To: Kittitas County Community Development
Attn: Zack Torrance-Smith, Staff Planner

From: Richard Rawlings
860 Alford Rd.
Ellensburg, WA 98926

RE: Jentges Conditional Use Permit (CU-26-00001)

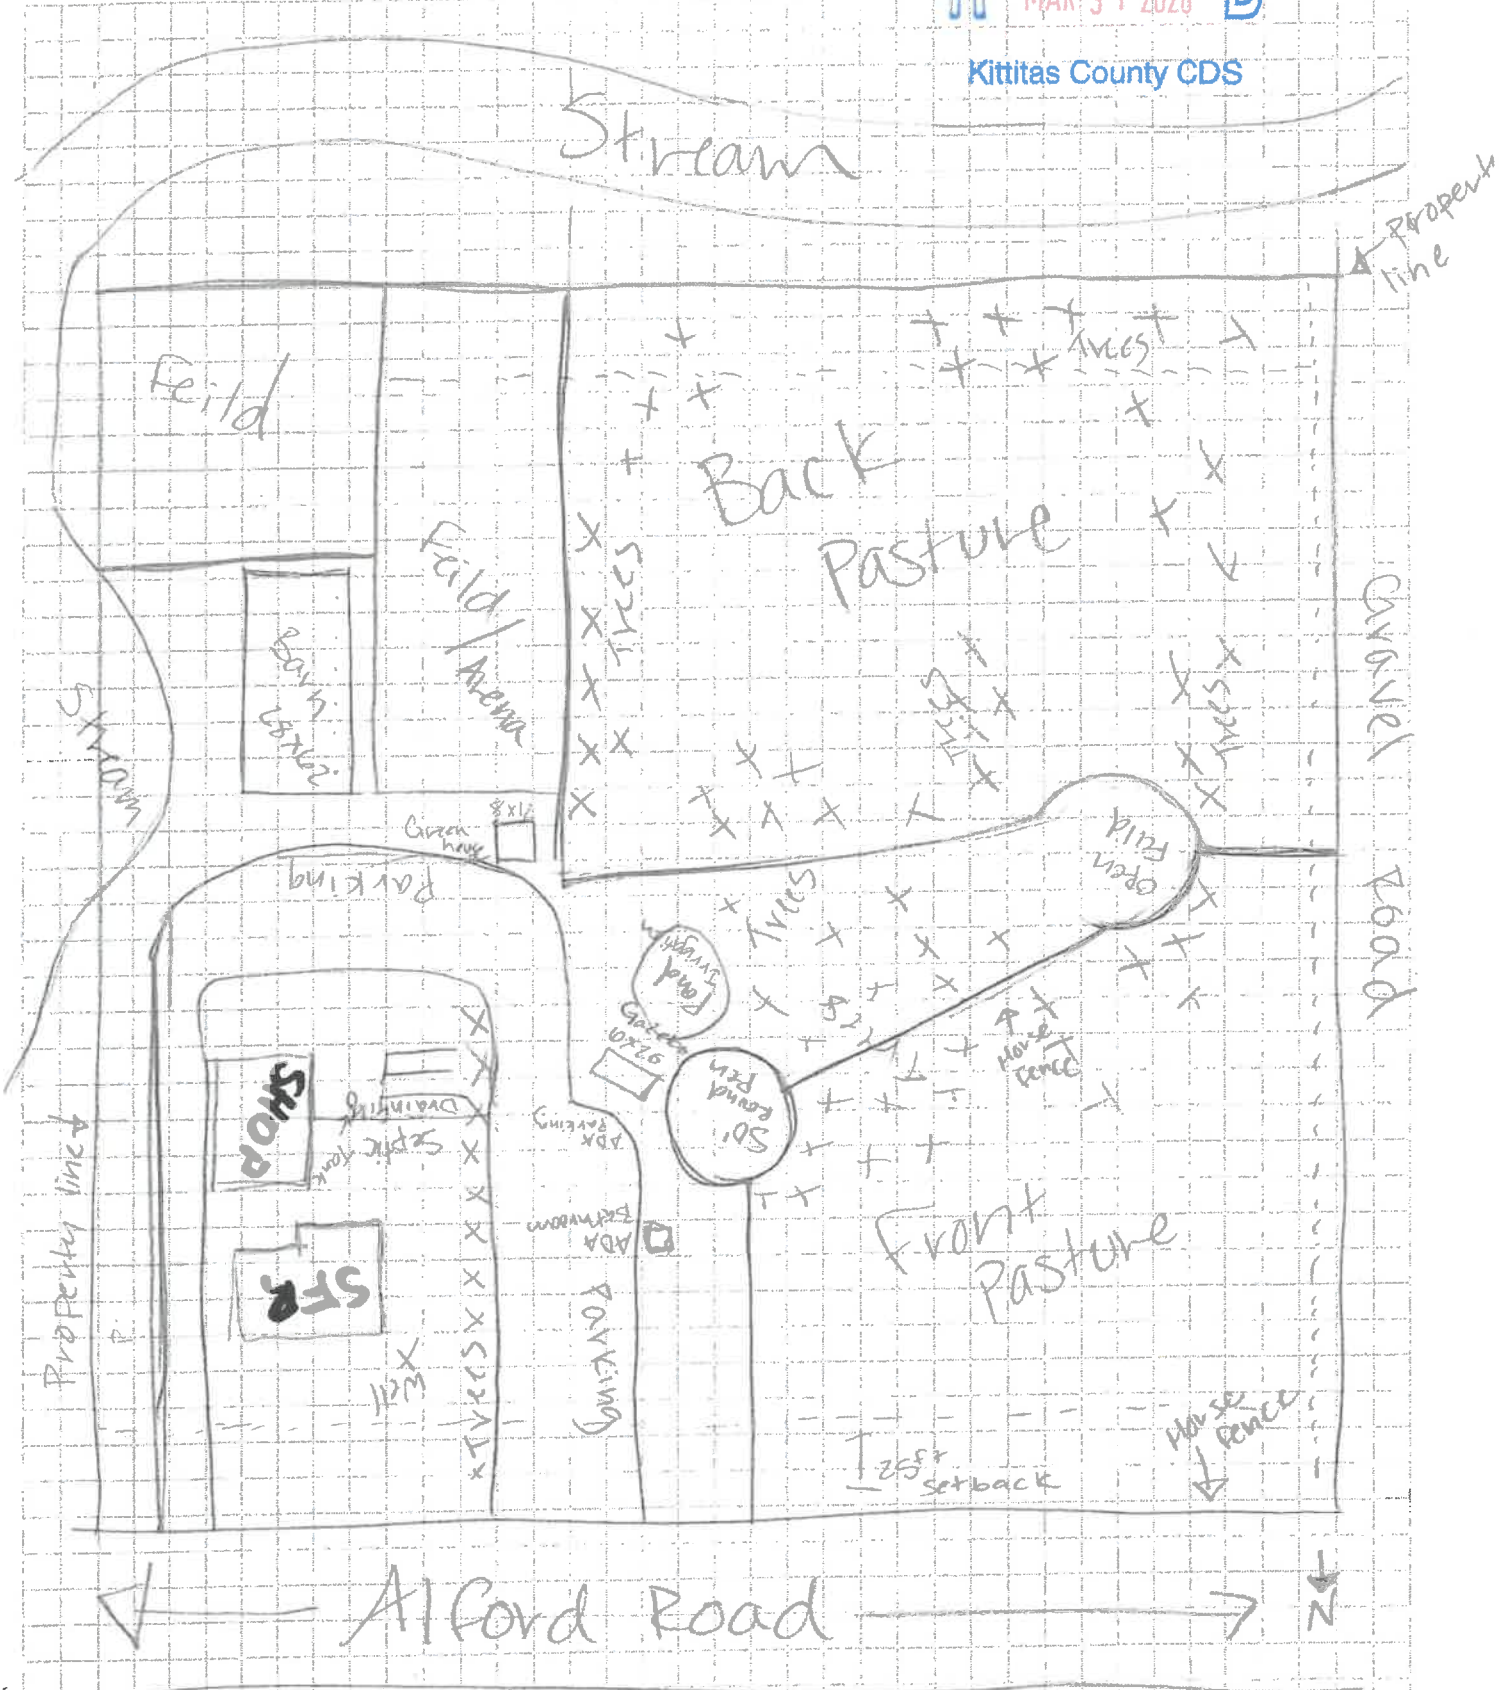
Daily or peak trips entering/exiting a 50 mph two lane road are unknown based on the available application materials. The CU application shows two driveways that are 100' apart on Allford Road, one existing and one new. Our driveway to Alford Rd. serves two homes and is within 250' feet of the recently installed driveway at the Applicant's property.

Our home is less than 100' from the proposed open-air event area, horse arena and the "riding academy", and pasture uses that presumably will be for on-saddle riding by guests. We understand that the yoga meadow activities will be directed by a nonresident instructor/practitioner.

We are also within 225' of the "Barn" described in the Narrative as animal occupied. We are concerned that this 2,000-sf building may be used in the future for large group occupancy unless conditioned otherwise by the CU Permit.

Parking for 25 cars is apparently proposed. This would indicate at least 25 and perhaps as many as 75 people could be on the Applicant's property at any given time.
